**COLORADO**  
**Department of Transportation**

June 4, 2020

RE: Trails at Aspen Ridge Filing #2 (Springs East at Waterview) - EA-SF1927

X,XXX = Average Daily Traffic (vehicles per day)

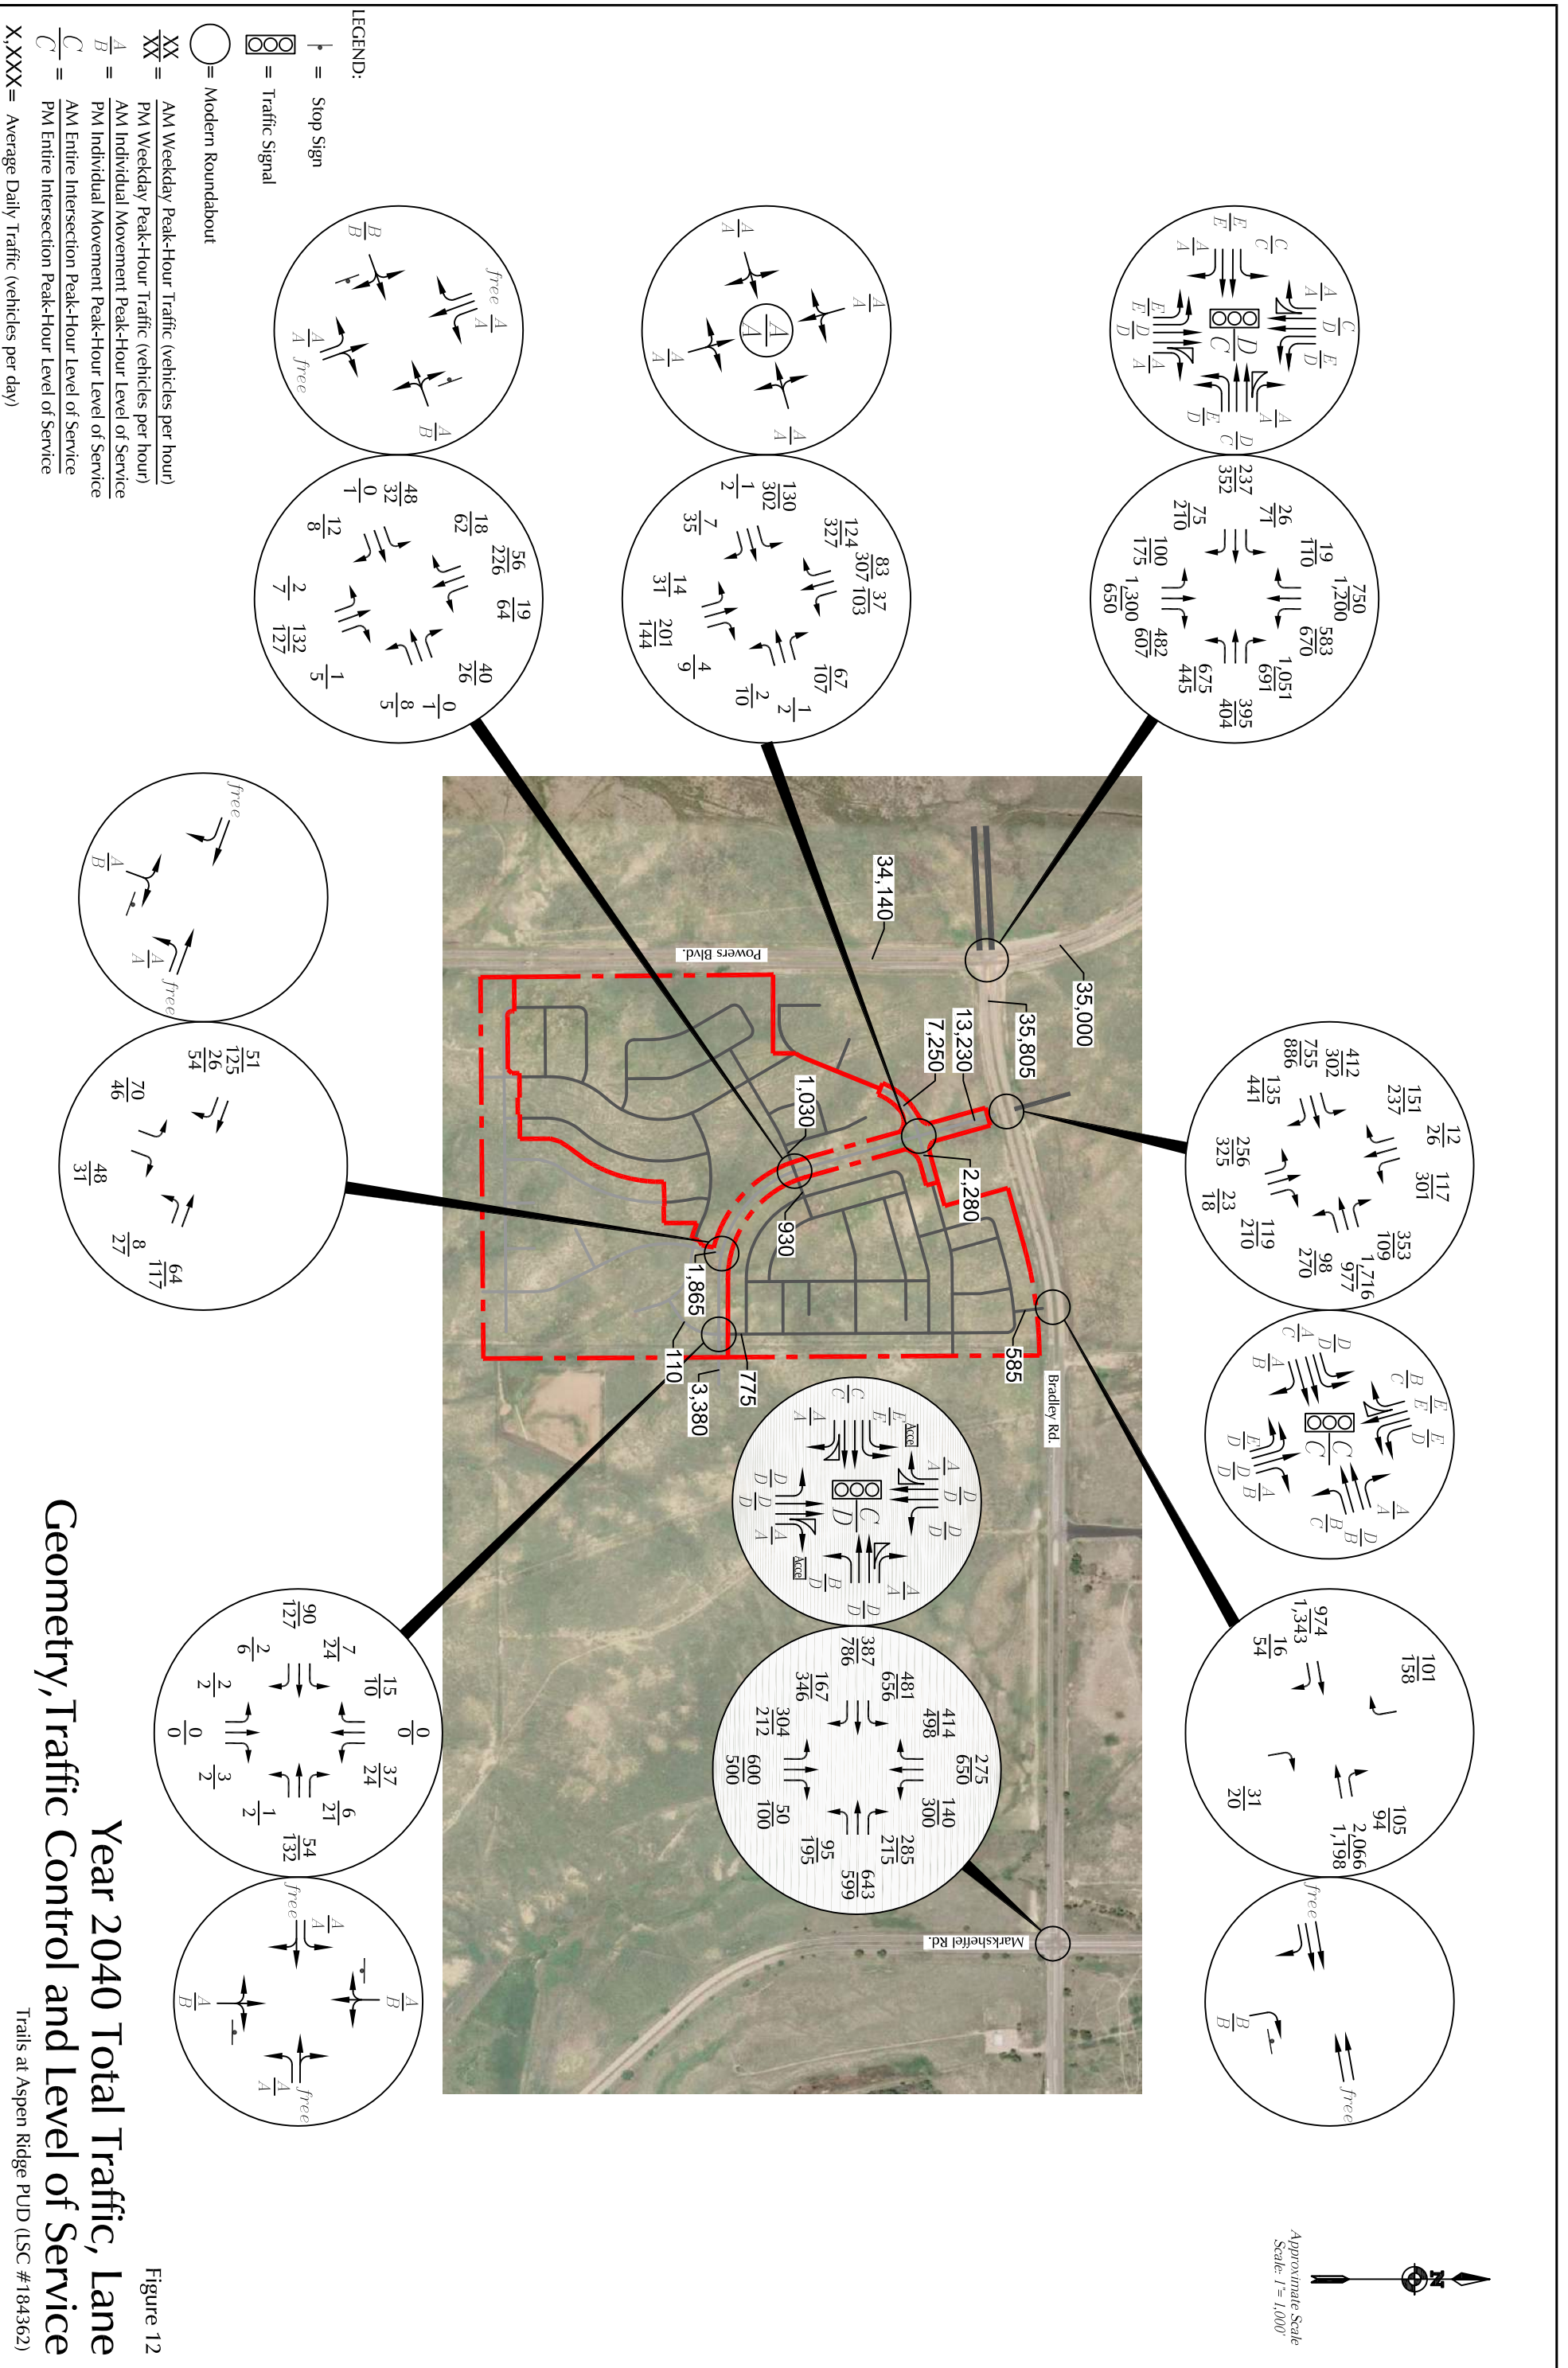
- g. The 2040 Synchro reports for Powers Blvd. Interchange Northbound Ramp at Bradley Rd is missing the existing left turn traffic in both time periods from Figure 13. Please update Figure 13.

TRAILS AT ASPEN RIDGE			
FILING NO. 1 ROADWAY & STORM IMPROVEMENT PLANS			
BRADLEY ROAD SIGNING & STRIPING			
DESIGNED BY: NMS	SCALE: 1" = 50'	DATE ISSUED: AUGUST, 2019	DRAWING No. SN01-B
CHECKED BY: NMS	HORIZ. N.A.	SHEET 17 OF 71

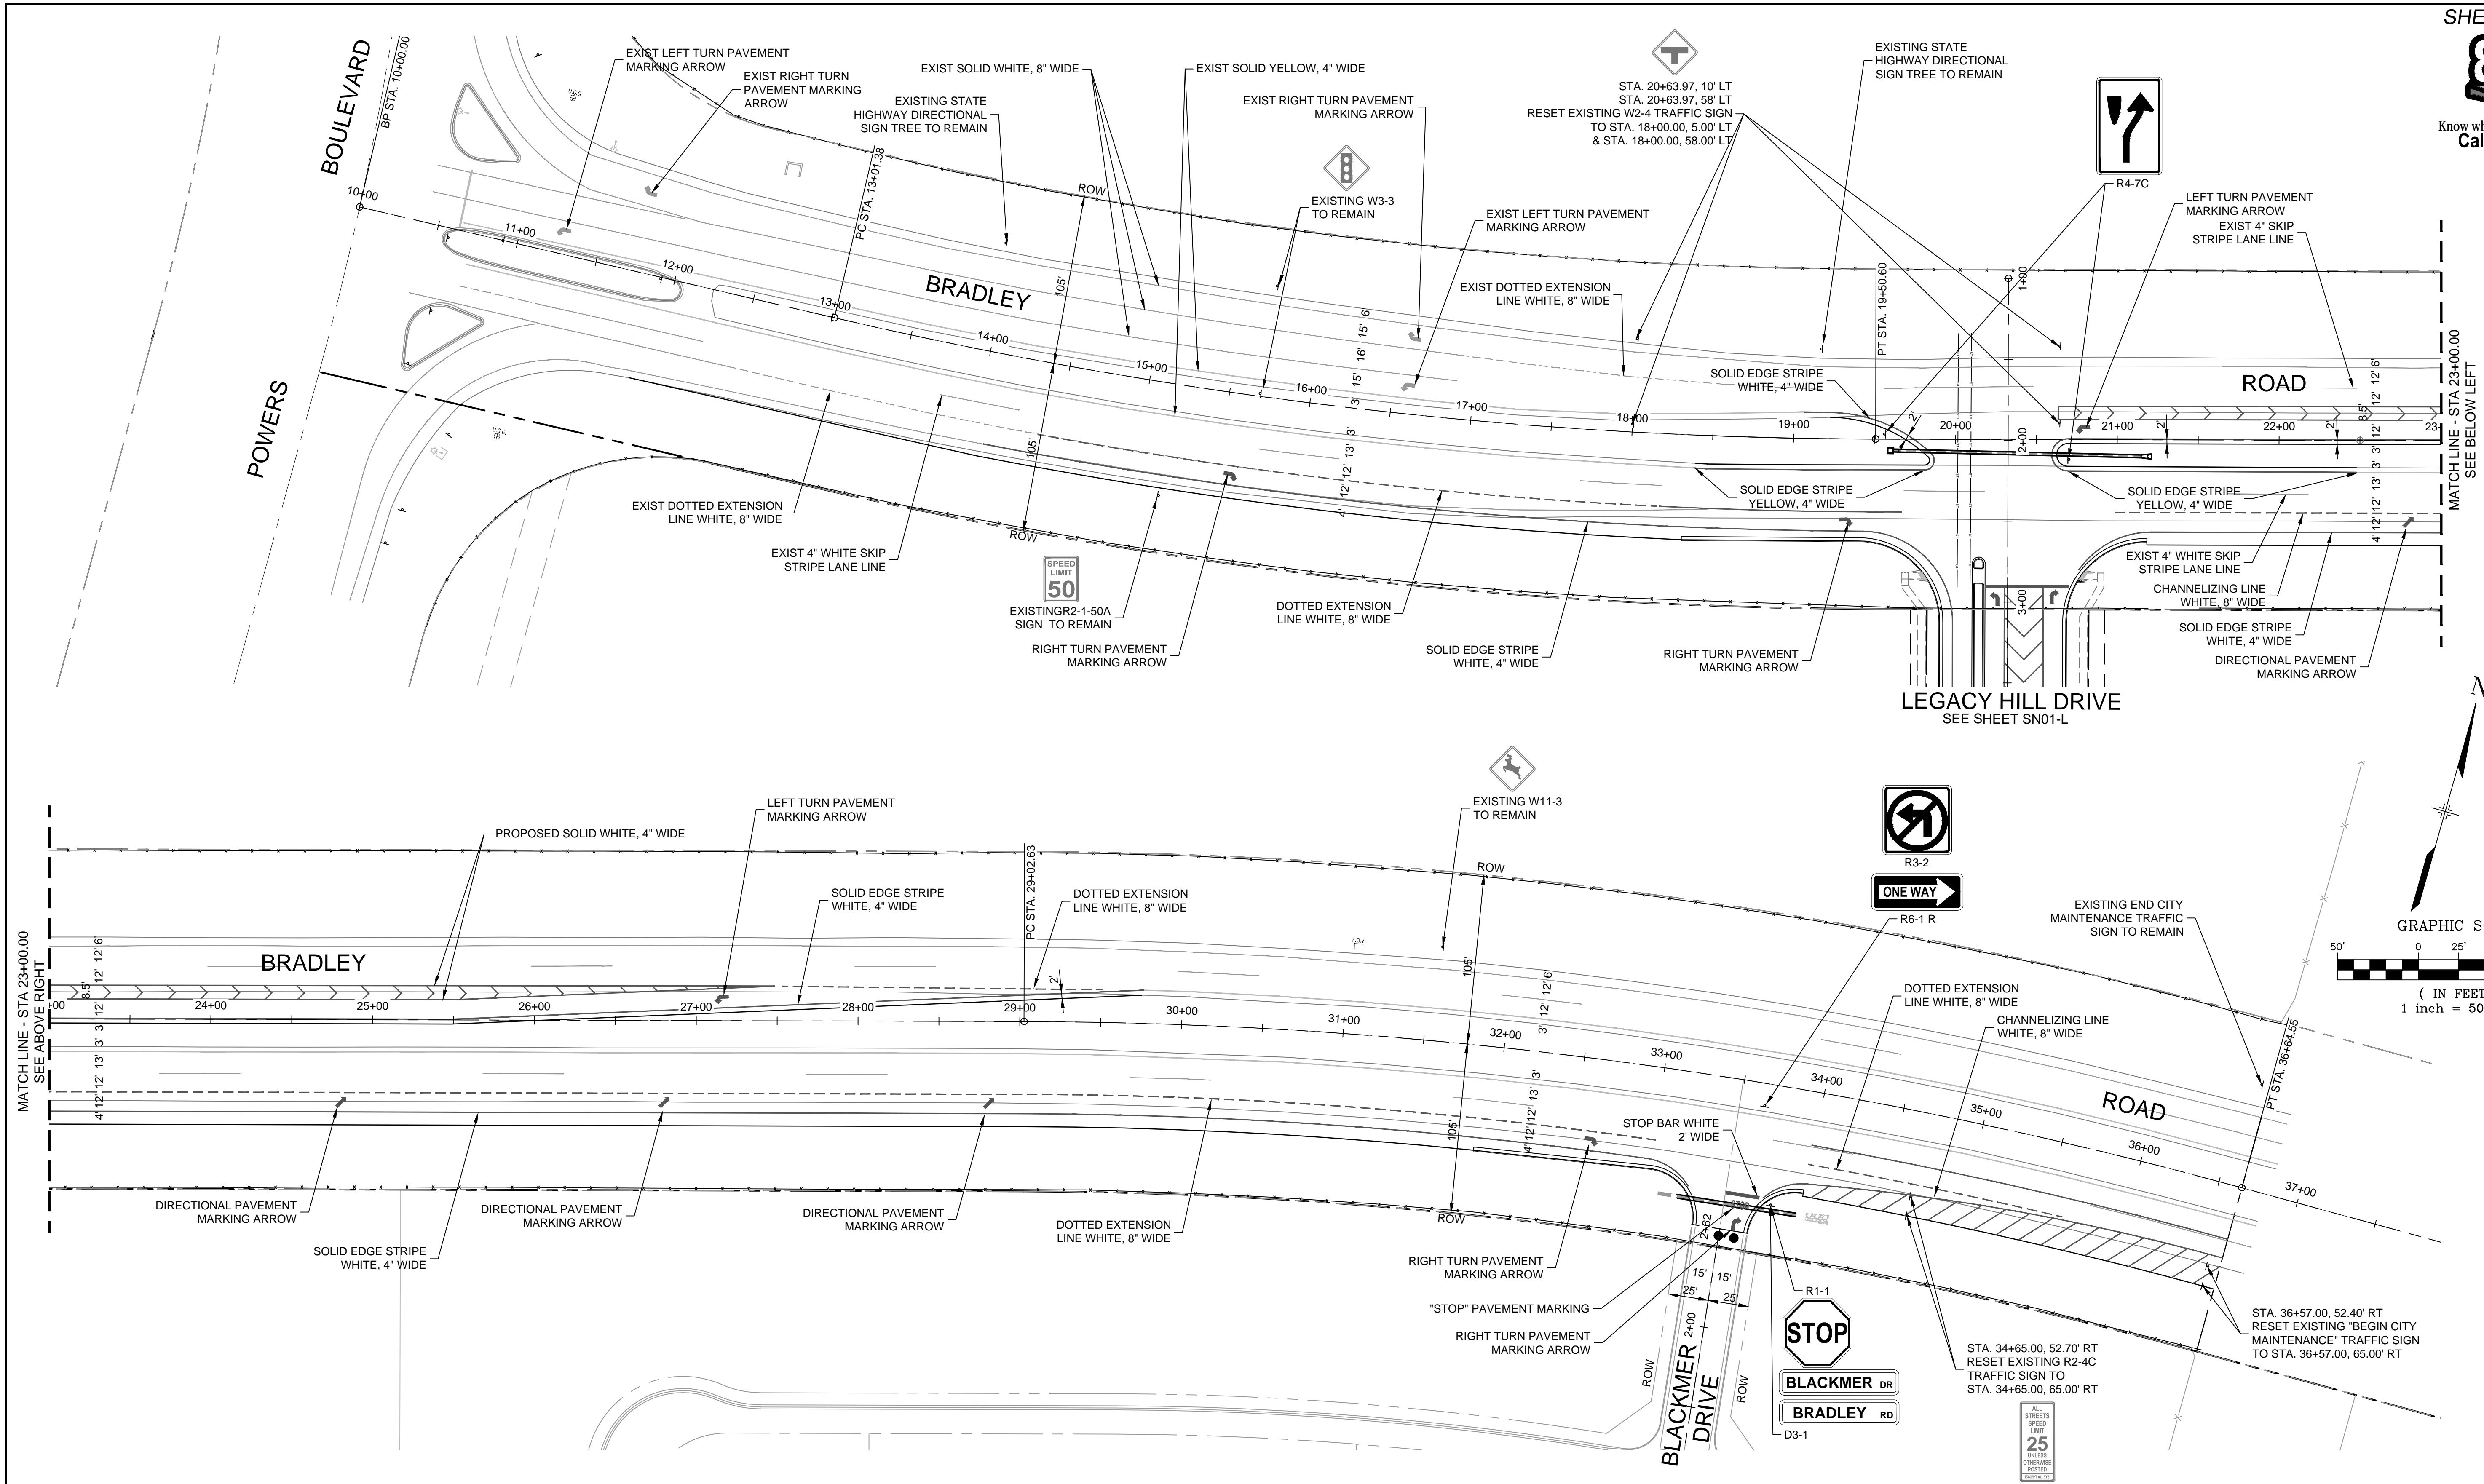
- d. The existing mast arm will need to be lengthened for the second left turn.
- e. Bradley Road has been restriped for dual westbound to southbound left turn lanes when the signal was installed; This will be required as part of the Access Permit, please update table 4.
